## Engineers Comments Regarding Surface Water Drainage

| <b>Application Reference:</b>   | FP/73/26/DOC                                                                                                         | <b>Reviewer Reference:</b> | ADC/EXT5/AF |
| <b>Site Name:</b>               | 1 Burley Road Felpham PO22 7NF                                                                                       |                            |             |
| <b>Application Description:</b> | Approval of details reserved by condition imposed under FP/176/24/PL relating to condition 3-surface water drainage. |                            |             |

CLIENT	
PROJECT	PROPOSED RESIDENTIAL DEVELOPMENT 1 BURLEY ROAD FELPHAM, PO22 7NF
DRAWING TITLE	DRAINAGE LAYOUT

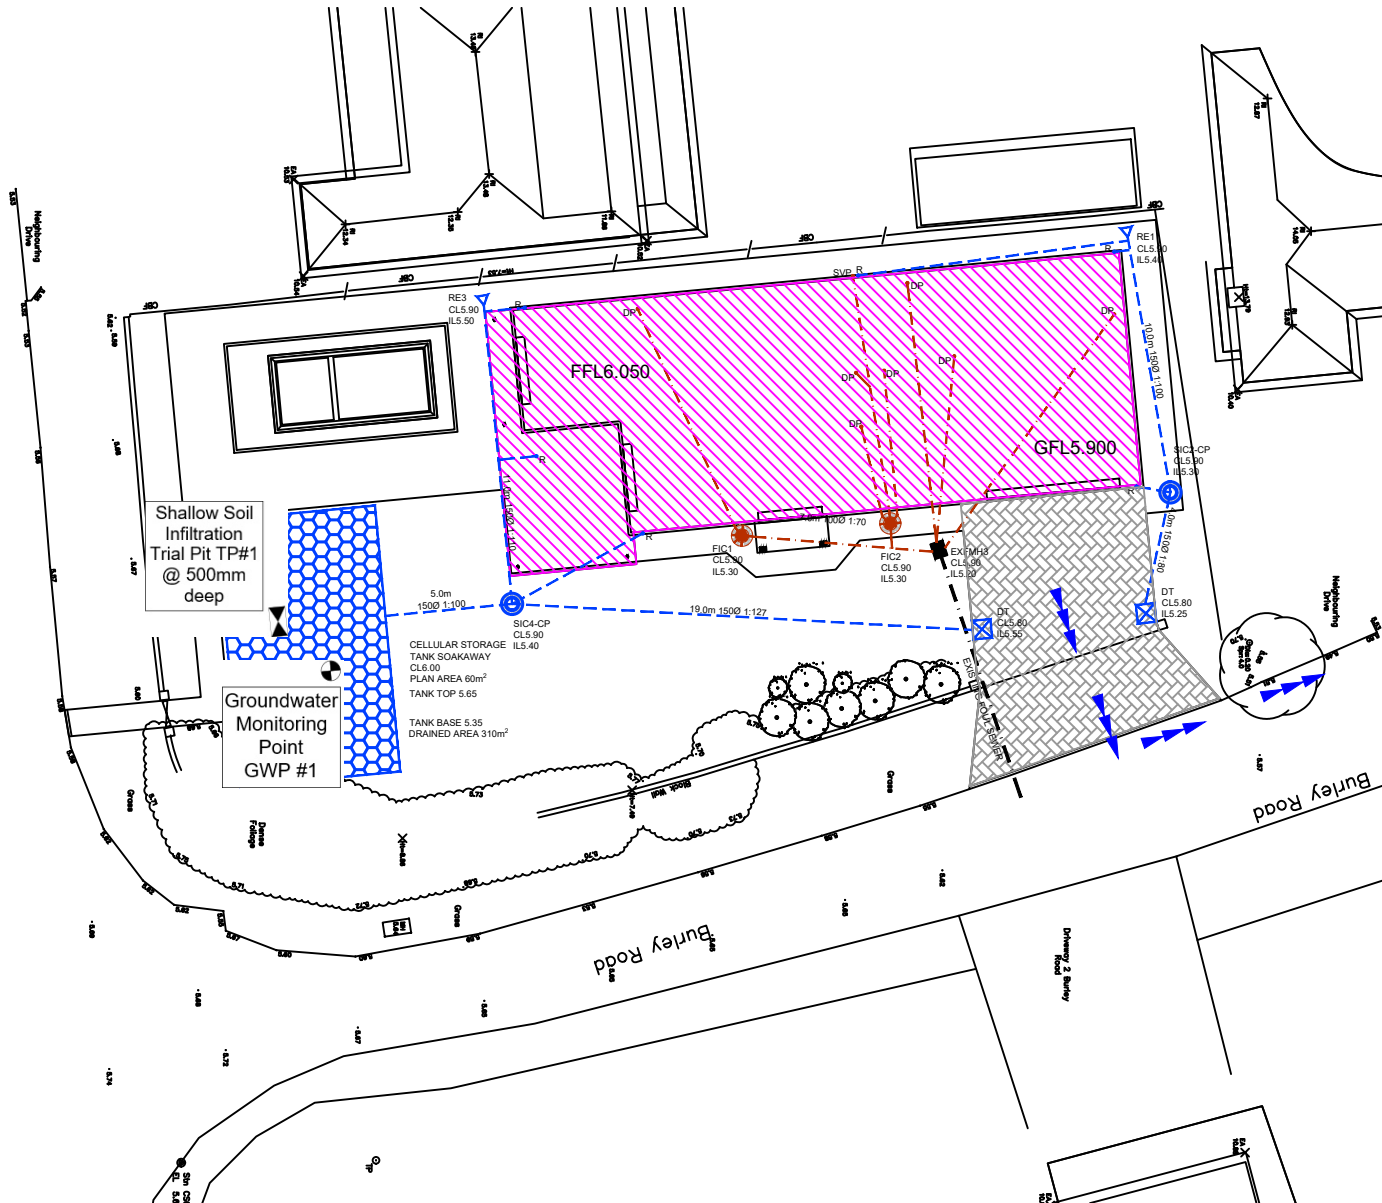
|                     | ADC Drainage Comments                                                                                                                                                                            | Designer Response                                                                                                                                                                                                                                                                                                                                                                                                                                                                                       | ADC Drainage Comments                                                                                                                                                                                                                 |  |  |
|---------------------|--------------------------------------------------------------------------------------------------------------------------------------------------------------------------------------------------|---------------------------------------------------------------------------------------------------------------------------------------------------------------------------------------------------------------------------------------------------------------------------------------------------------------------------------------------------------------------------------------------------------------------------------------------------------------------------------------------------------|---------------------------------------------------------------------------------------------------------------------------------------------------------------------------------------------------------------------------------------|--|--|
| 1.                  | The calculations currently total 270sqm drained area but the drainage plan states 310sqm. A drained areas plan should be provided to set out the drained area and clarify Urban Creep allowance. | The discrepancies on the original Drainage Layout Plan have been addressed and a new Drainage Layout Plan has been issued, raised to revision P8. A new Drained Areas Plan has been created detailing the contributing impermeable areas and has clarified the Urban Creep Allowance associated with each area. This new drawing is at revision P8. The consequence of including the correct Urban Creep Allowance is that the Geocellular Soakaway Structure has been increased in its footprint area. | The drained areas plan is acceptable, however, revised FLOW drainage calculations have not been provided. Rounding up to the nearest allowable decimal place is appropriate. The revised calculations should be submitted for review. |  |  |

| 2. | Finished levels design information should be provided. | <p>Since there is levels information provided for the Finished Floor Levels (FFL), the Garage Floor Level</p>                                                                                                                                                                                                                                                                                                                                                                                                                                                                                                                                                                                                                                                                                                                                                                                                       | Comment closed. |  |  |

| 3. | There are two permeable pavement details, the plans should differential where they are to be constructed. Note also the access road details should specify the holes in the road base including spacing and size. | The Constructional Details Drawing (sheet No. 2) showed a detail for the Permeable Pavement for a POROUS PAVED ACCESS ROAD/SHARED DRIVE DETAIL with a "tarmac running layer". This detail is completely erroneous and irrelevant and is not incorporated within the original design and its inclusion can only be assumed to be an error. This superfluous detail has been deleted from the Constructional Details Drawing (sheet No. 2) which has been raised to revision P2. The full Permeable | Comment closed. |  |  |

| 4. | Details for the venting for the soakaway should be provided.                                                                                                           | The location and general details for the (direct atmospheric) venting of the soakaway has been included on the Drainage Layout Plan and the full details of the vent assembly, including the manufacturer and model type, has been incorporated on the Constructional Details Drawing (sheet No. 2)                                                                                                                                            | Comment closed.                                                                         |  |  |

|    |                                                        | <p>It should be noted that the measured main building impermeable area is 198 metres<sup>2</sup>. Urban Creep Allowance of +10% gives an addition of 19.8 metres<sup>2</sup>, producing a total of 217.8 metres<sup>2</sup>.</p> <p>Causeway Flow handles its areas in hectares, with a minimum available area of 0.001 hectare (10 metres<sup>2</sup>), so is unable to resolve areas smaller than this. This is why Causeway Flow has used 0.020 hectares as its 'rounded' contributing area (200 metres<sup>2</sup>), as it is unable to resolve to 198 metres<sup>2</sup>.</p> <p>The modelling used here is generally for smaller developments and is capable to resolve contributing areas to 2 decimal points of a metre<sup>2</sup> as a 'floating point number'. Additional information has also been added to each of the drawings, as regards the soil investigations, to aid with the consultation.</p> |                 |  |  |

|    |                                                                                                                                                                                                                   | (GFL), the Geocellular Soakaway Structure, the individual drainage components and the original Topographical Survey, I can only assume that the consultation, when referring to the <i>'finished levels design information'</i> , relates to the permeable pavement. The relevant design levels have now been incorporated on both the Drainage Layout Plan and the Impermeable areas Plan.                                                                                                       |                 |  |  |

|    |                                                                                                                                                                        | Pavement ENTRANCE & DRIVEWAY with a footprint area of 70 metres <sup>2</sup> is the only relevant detail on this drawing.                                                                                                                                                                                                                                                                                                                      |                                                                                         |  |  |
